Cottam Solar Project

Draft Statement of Common Ground with Scunthorpe & Gainsborough Water Management Board

PINS Ref: EN010133
Document reference: EX4/C8.3.15
Infrastructure Planning (Examination Procedure) Rules 2010

### Figure 8.16.2: Landscape and Ecology Mitigation and Enhancement Plan – Cottam 1 North (Sheet 2) Revision A

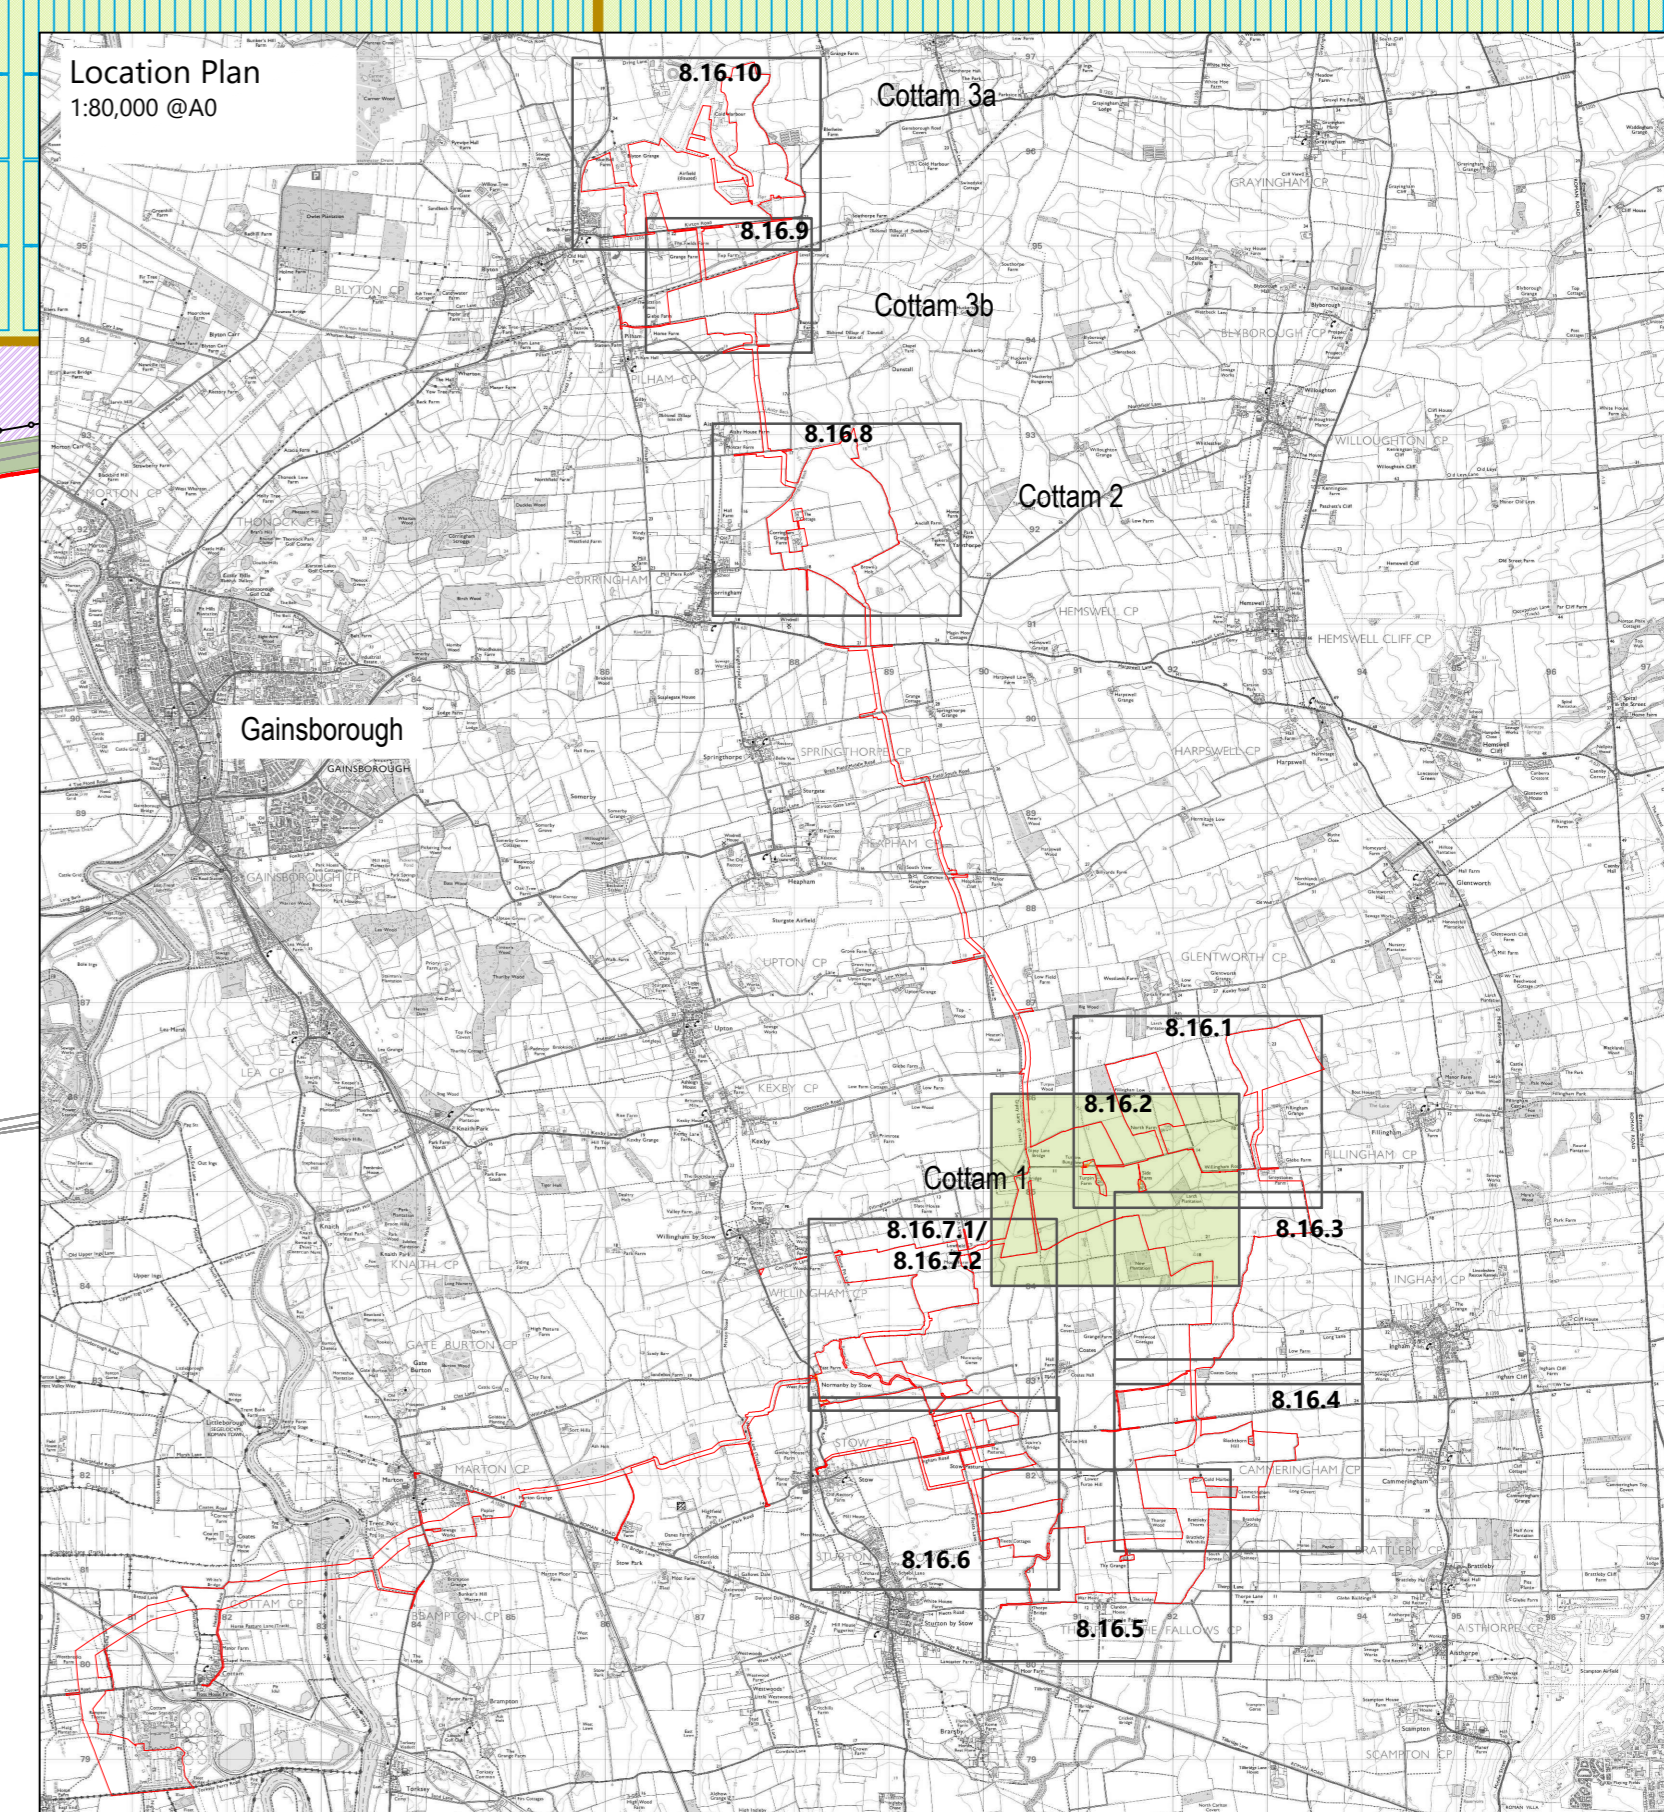
works” within 9m of any of the IDB’s drains/watercourses. Please also see the response to HY-03 below.
<u>Hydrology</u> <u>HY-02</u>	Identification of Watercourses	<p><i>“Figure 8.16.2: IDB watercourses not clearly identified.”</i></p> <p>S&GWMB have identified assets which may be impacted by the proposed scheme.</p> <p><u>S&GWMB maintained watercourses</u></p> <p><i>Work Plan 2 (P2981_LPR_ZZ_ON_DR_Z_0064)</i></p> <p>Work Package 6A may impact on the 9m easement on both sides of Aisby Beck</p> <p><i>Work Plan 3 (P2981_LPR_ZZ_ON_DR_Z_0064)</i></p> <p><i>Work Package 1B may impact on the 9m easement on Corringham Beck, Yawthorpe Beck and River Eau ordinary watercourse (upstream of main river).</i></p>	<p>These IDB watercourses and drains have been considered throughout the layouts with a 9m offset as has been possible and as shown on Landscape and Ecology Mitigation and Enhancement Plans (Figures 8.16.1 to 8.16.10) [APP-305 to APP-315]. The Applicant has discussed this matter with the IDB and both parties are in agreement that the scale of the Scheme makes it impossible to provide the full information regarding detailed design at this stage.</p> <p>The Applicant notes that the drawings are based on the currently available data and mapping and in some cases the ‘top of bank’ is not defined. It notes that further survey work will be required to establish the ‘top of bank’ which will in turn give the 9m offset and required clear working access. The IDB can provide a shape file to confirm the locations during the detailed design stage post DCO consent.</p> <p>The Applicant will then provide a specific plan to the IDB at the detailed design stage (post DCO consent) to give clear details of all 9m</p>
